Comment from Greenspace

APPLICATION BN/6/18/RES

Description of Works: Approval of reserved matters following outline consent BN/32/15/OUT relating to appearance, landscaping, layout & scale for erection of 38 No. dwellings including open space, landscaping & new access (resubmission following BN/28/17/RES).

scheme: The Lillies, Yapton Rd
Barnham
client: Matthew Homes
drawing: Landscape Proposals
date: April 2017
scale: 1:200@A1
drawing no: MAT21212 11G sheet 1
drawn: AE checked: DKM

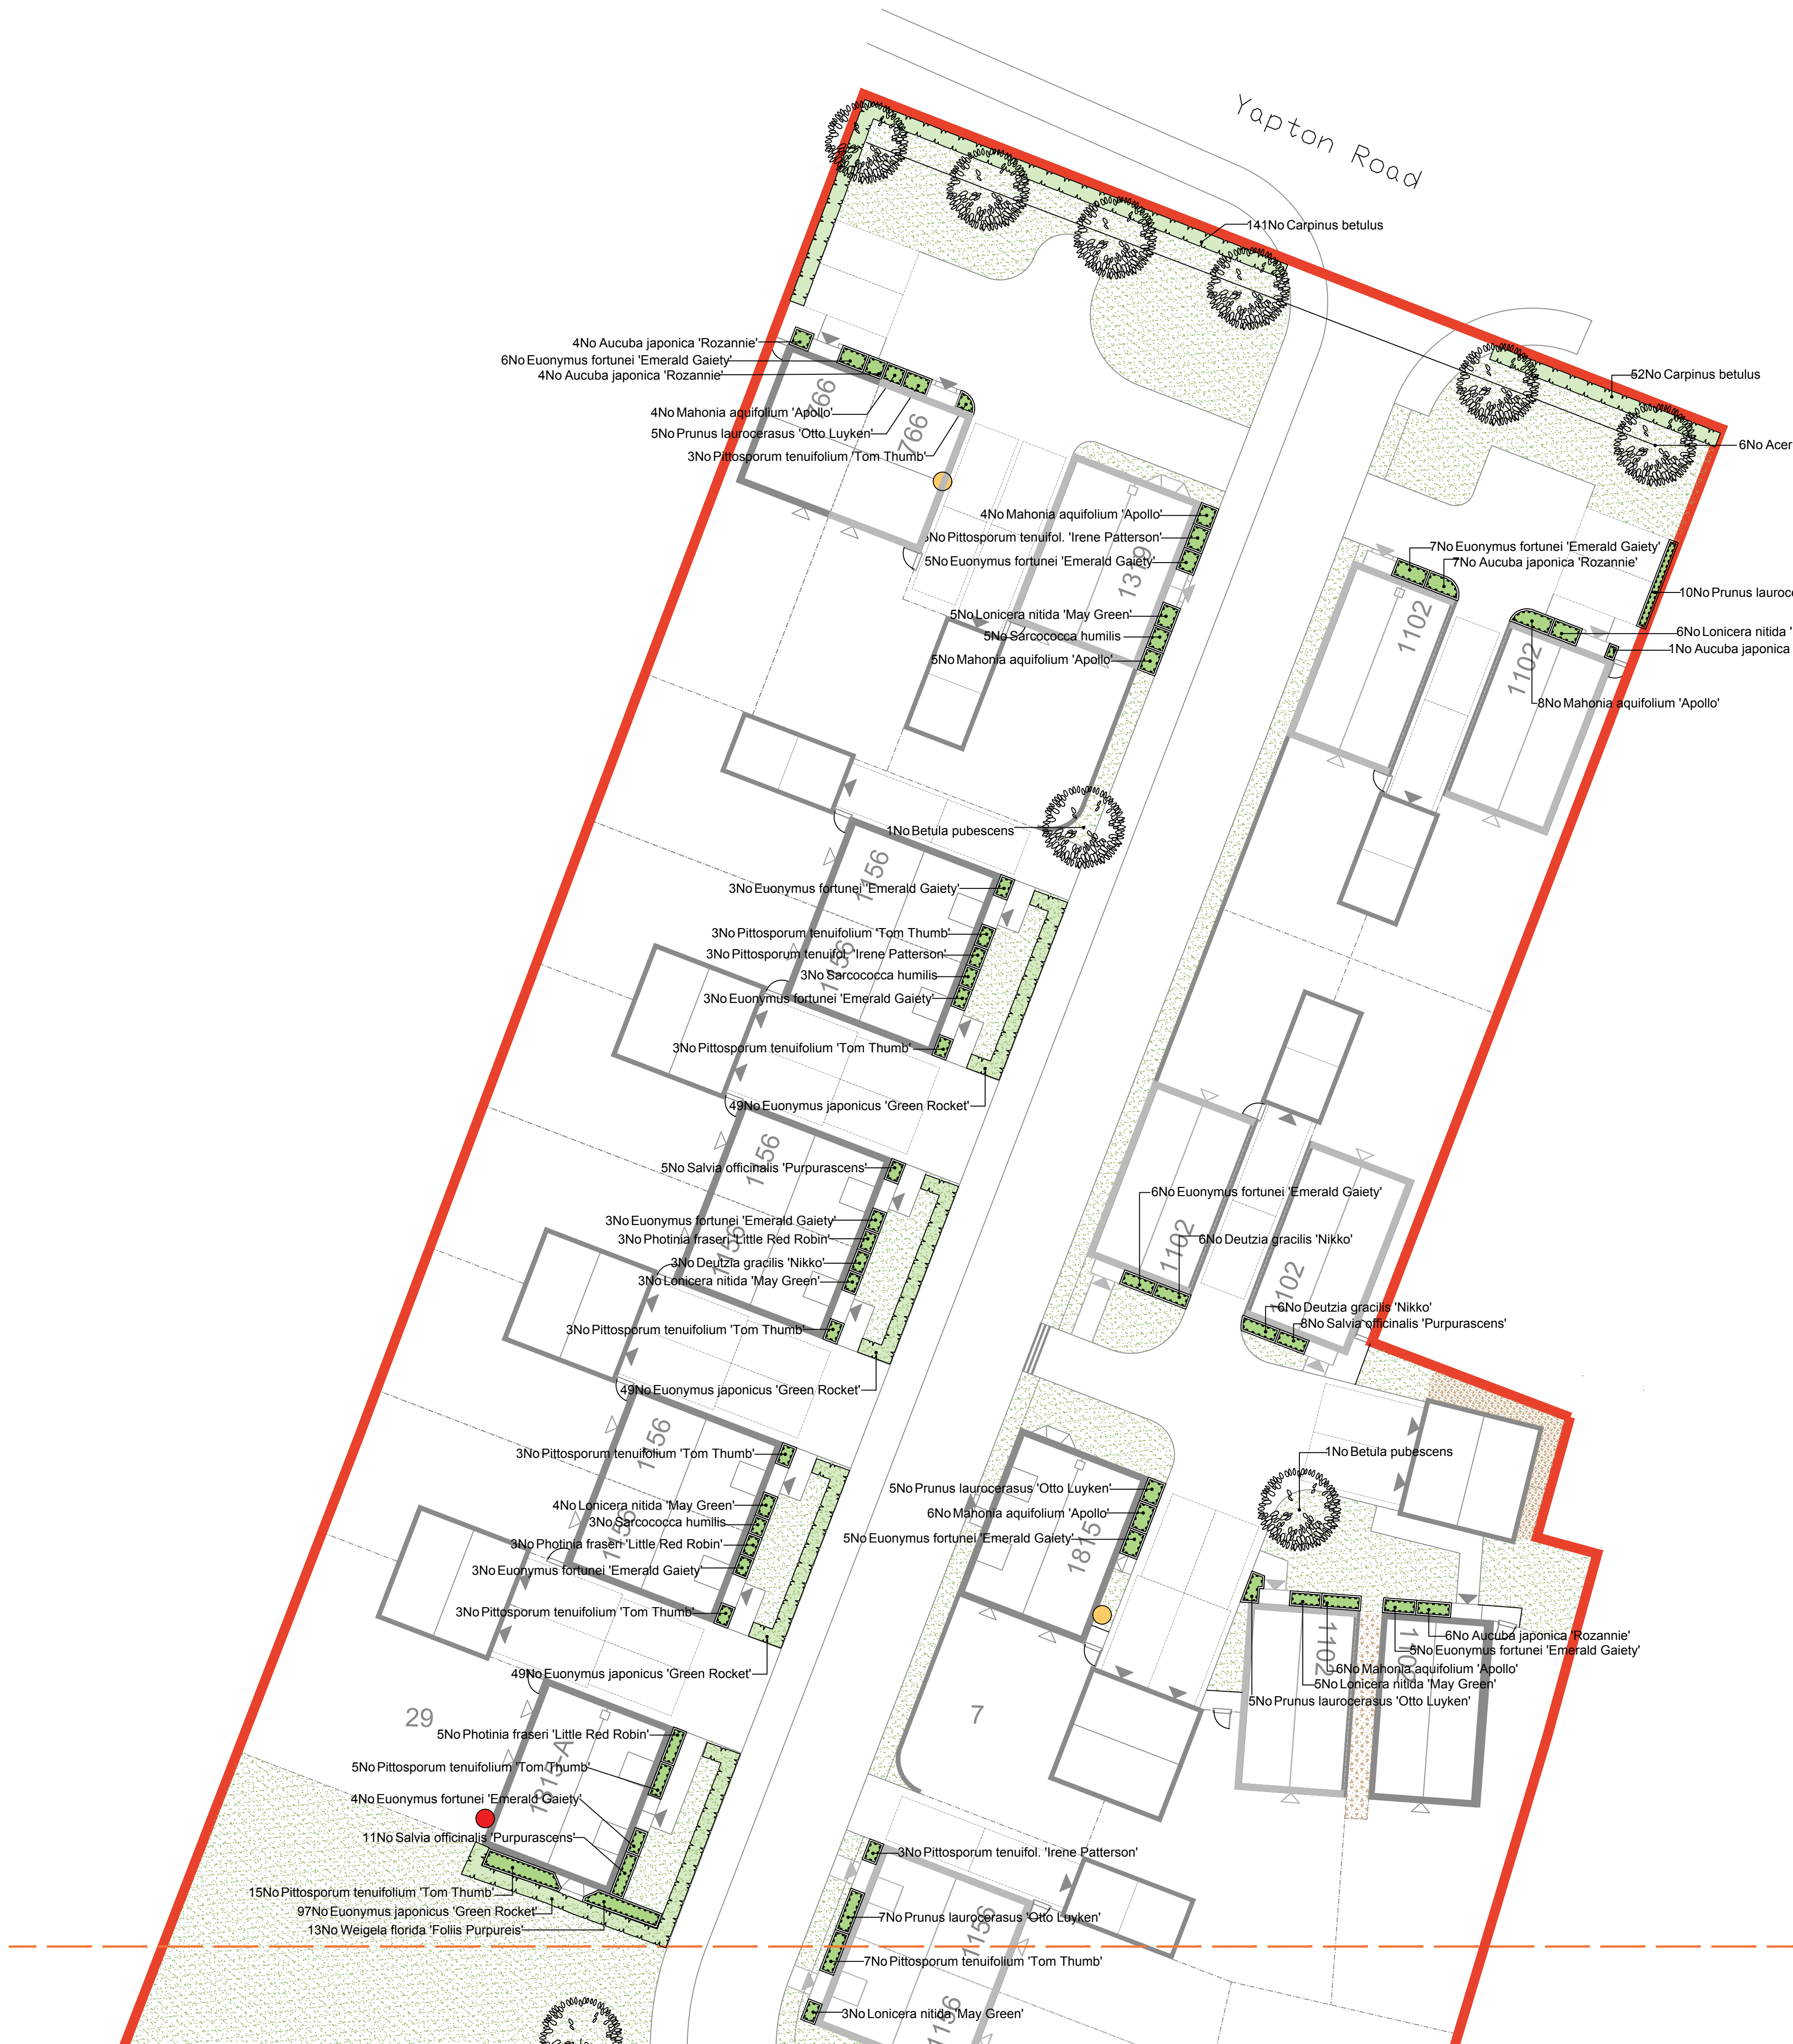
Further to submission of Dwgs MAT 21212 11 G Rev H sheets 1 & 2, we have viewed the information submitted and the layout changes proposed. Whilst it is good to see that further consideration to the provision for open space within this development has been made and it is good to see that open space frontage and grass verges within the development have been improved, the total quantity of POS proposed still appears to fall considerably short of what should be being provided for this development.

The Council's SPG guidelines apply to developments of houses and are based broadly upon the National Playing Fields Association's (NPFA) "Six Acre Standard". This requires that 2.4 hectares of open space (or six acres) are provided for every 1,000 people ie 24 square metres of open space per person. With the number of dwellings on this proposal being 38 this would require onsite landscaped open space. Under superseded Fields in Trust guidelines (FIT) this requires that 3.2 hectares of open space are provided for every 1,000 people ie 32 square metres of open space per person. We would require confirmation of the areas of public open space being proposed with this development, where 2,918m² would be recommended as a minimum for this development. The POS total areas should be confirmed in quantity detailing what is being provided.

The proposed SuDS provision still takes up a large proportion of the POS area being provided, so in conclusion the under provision in quantity and quality of POS on this development in relation to units being proposed would lead me to have to recommend an objection to the reserved matters application BN/6/18/RES on Landscape grounds as presently submitted.
